CITY OF ALBUQUERQUE

RE: Swim Labs
8110 Holly Ave NE
Grading Plan Stamp Date: 7/19/19 & 7/24/19
Drainage Report Stamp Date: 7/25/19
Hydrology File: C20D082

Based on the submittal received on 7/25/19, the grading plan and drainage report cannot be approved until the following are corrected:

## GRADING & DRAINAGE PLAN

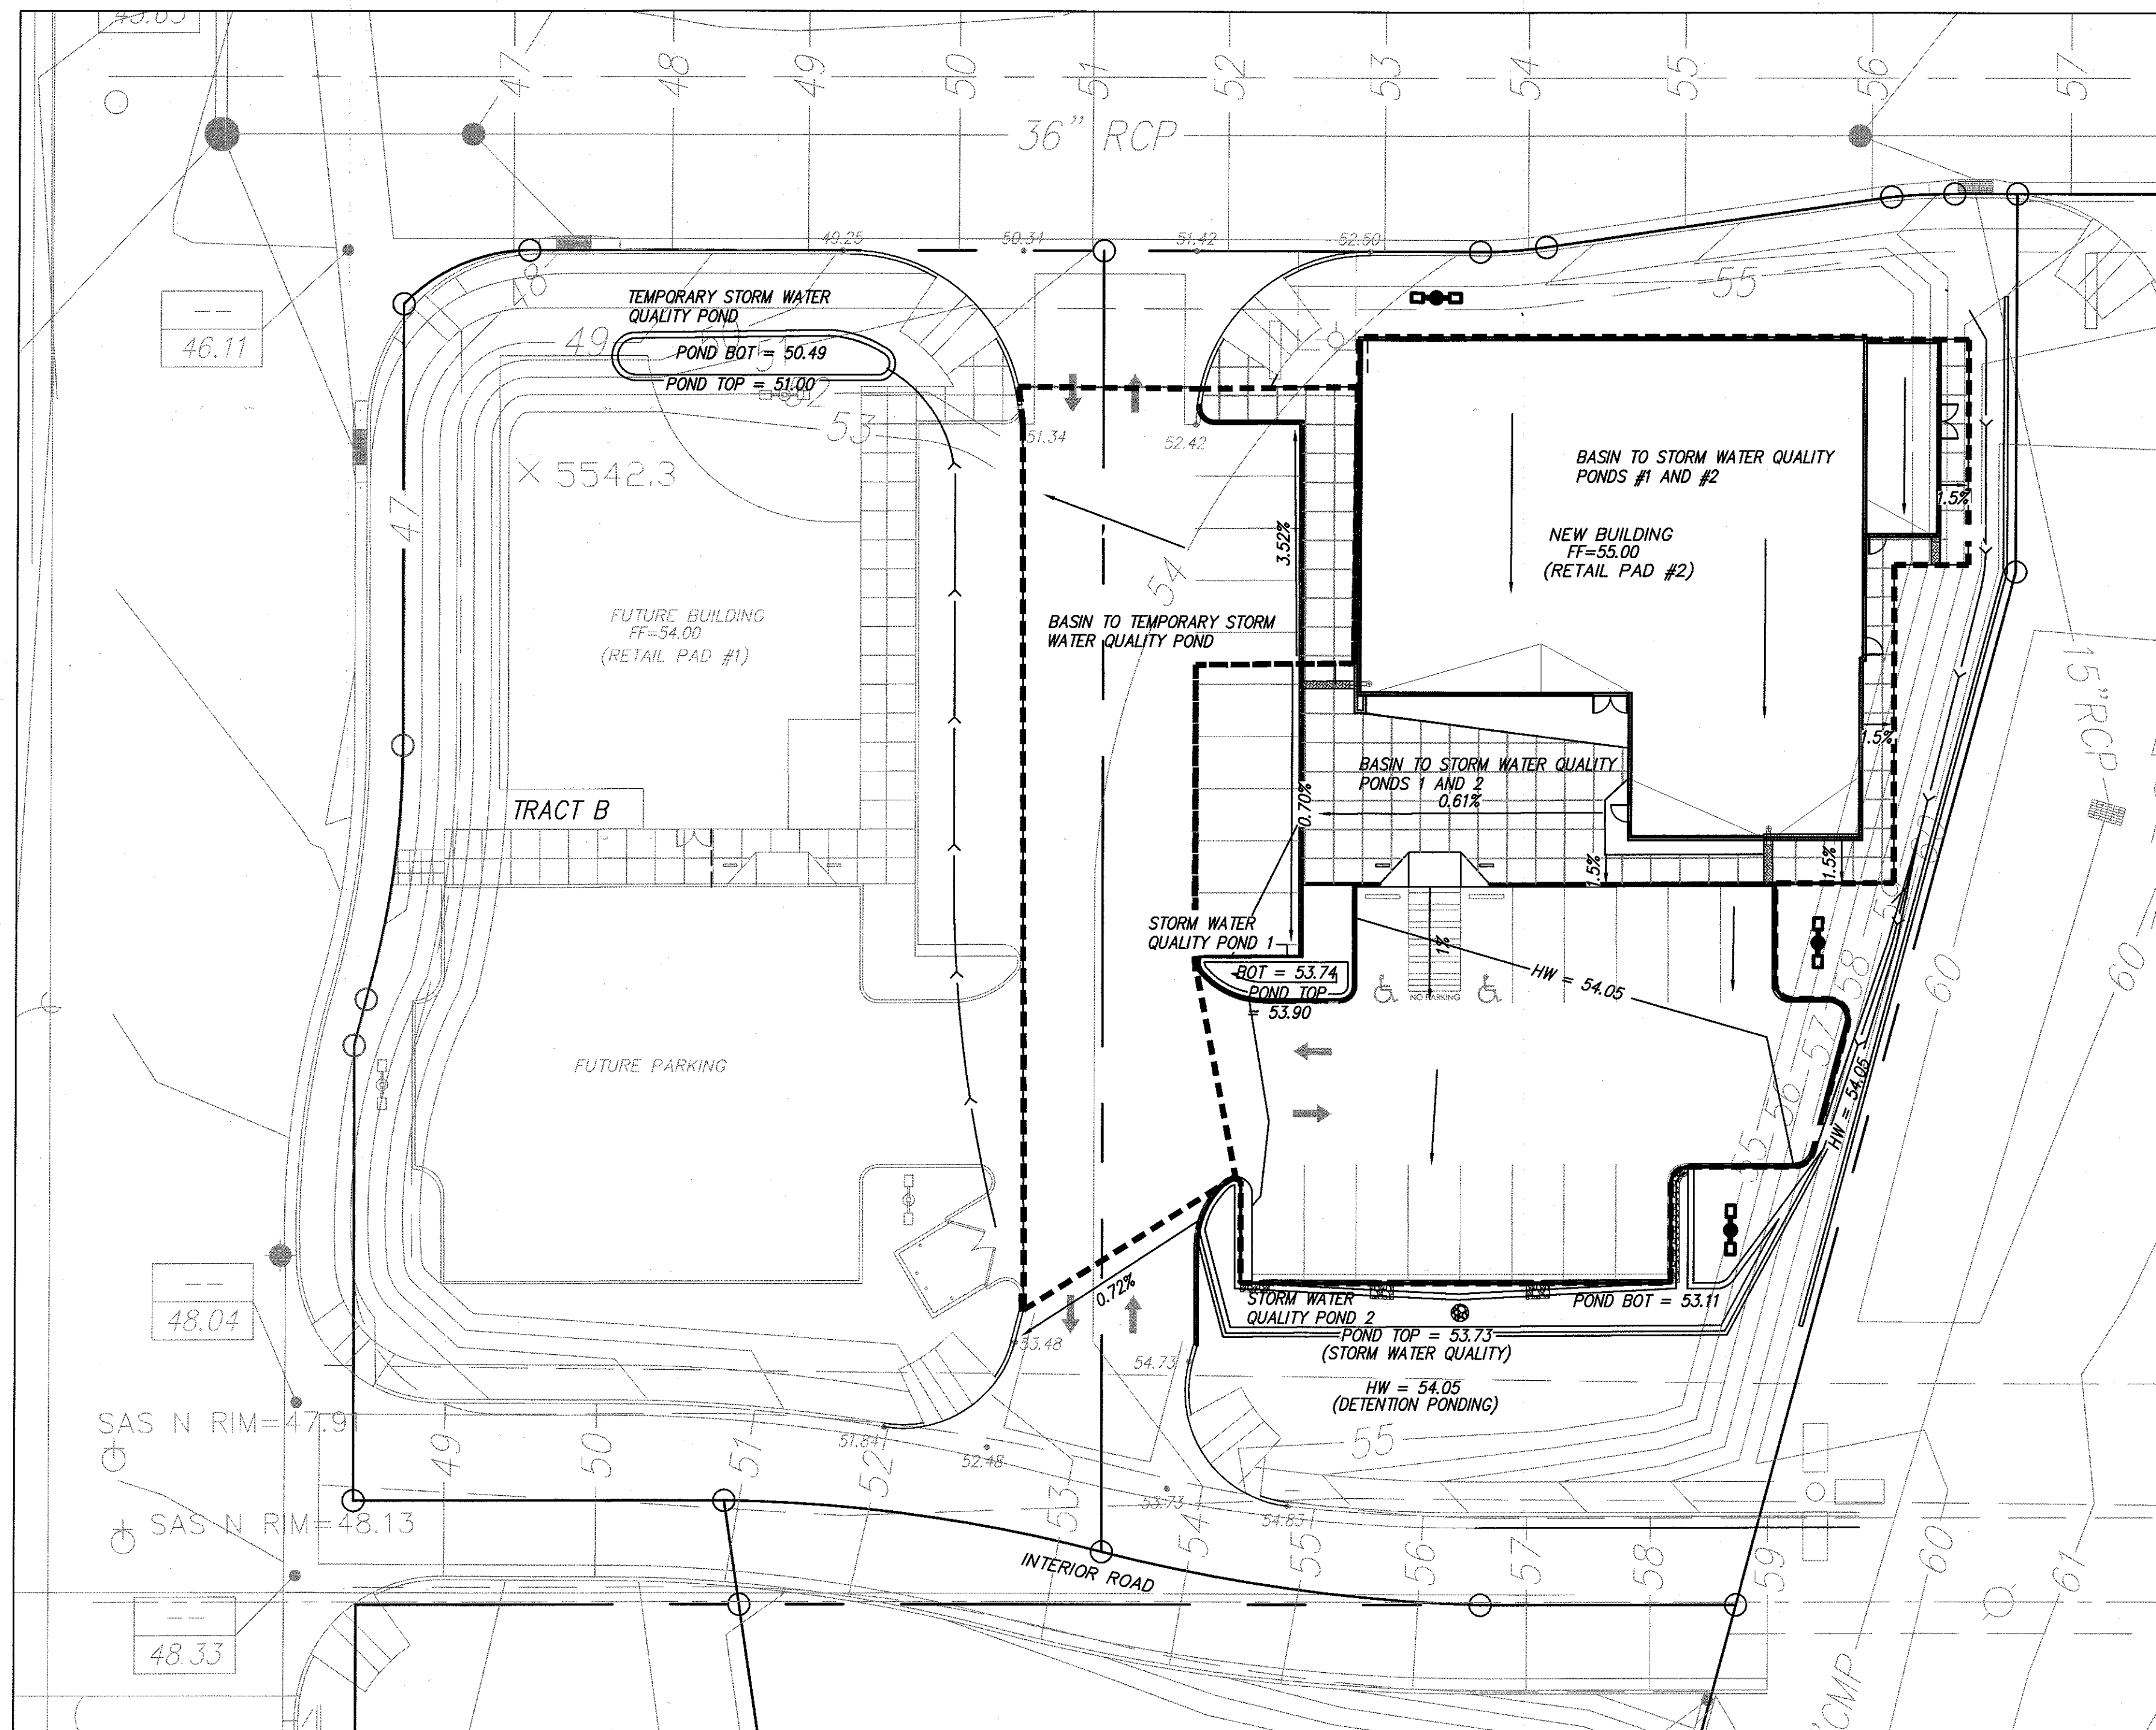
1. Provide sections through the east boundary showing the proposed retaining wall, property lines, existing and proposed grades. In accordance with DPM Ch.22, section 5 part B, grading and wall construction near the property line may not endanger adjacent property or constrain its use.

2. Any private encroachment into neighboring private property will require written and signed permission from both property owners.
3. Include a detail where the retaining wall crosses over the private storm drain; ensure adequate clearance.

4. Provide written and signed permission from the owner of Tract B for the grading, paving and pond construction on their property. Unfortunately the cross-lot drainage easement does not grant the right to perform work on their property, only to discharge to it. (A permanent pond covenant will also be needed from this owner prior to CO; you may want to get it now)

5. Provide project datum. This needs to be on the plan where the benchmark is cited. The benchmark, existing survey, and proposed work all need to be converted to NAVD88 and NAD 83.

6. The proposed contours need to be cleaned up. For instance, the 54' contour cuts through the building (FF=55'), the 53' contour seems to be missing, and there appear to be different contours used for the ponds that don't tie-in to anything.

7. Hydrology recommends against using the parking lot as dead storage for ponding water (Pond 2).
8. An SO-19 Permit will be required for the sidewalk culvert and should be included on the request. Please include the [standard SO-19](#) notes on the grading plan.

9. Discharge from this site needs to be limited to 0.93cfs per the approved master plan; do not rob capacity from the adjoiner (Pad 1).
10. Remove the open channel and extend the plate to the curb and 1' beyond back of sidewalk; also remove the non-standard plate detail and build per Std Dwg 2236.

11. Please provide the weir calculations, per DPM Chapter 22.3.A.1, for the sidewalk culvert. A coefficient of 2.7 is typically used for the weir equation $Q = CLH^{2/3}$. Be sure to size for future developed flow (1.16cfs).
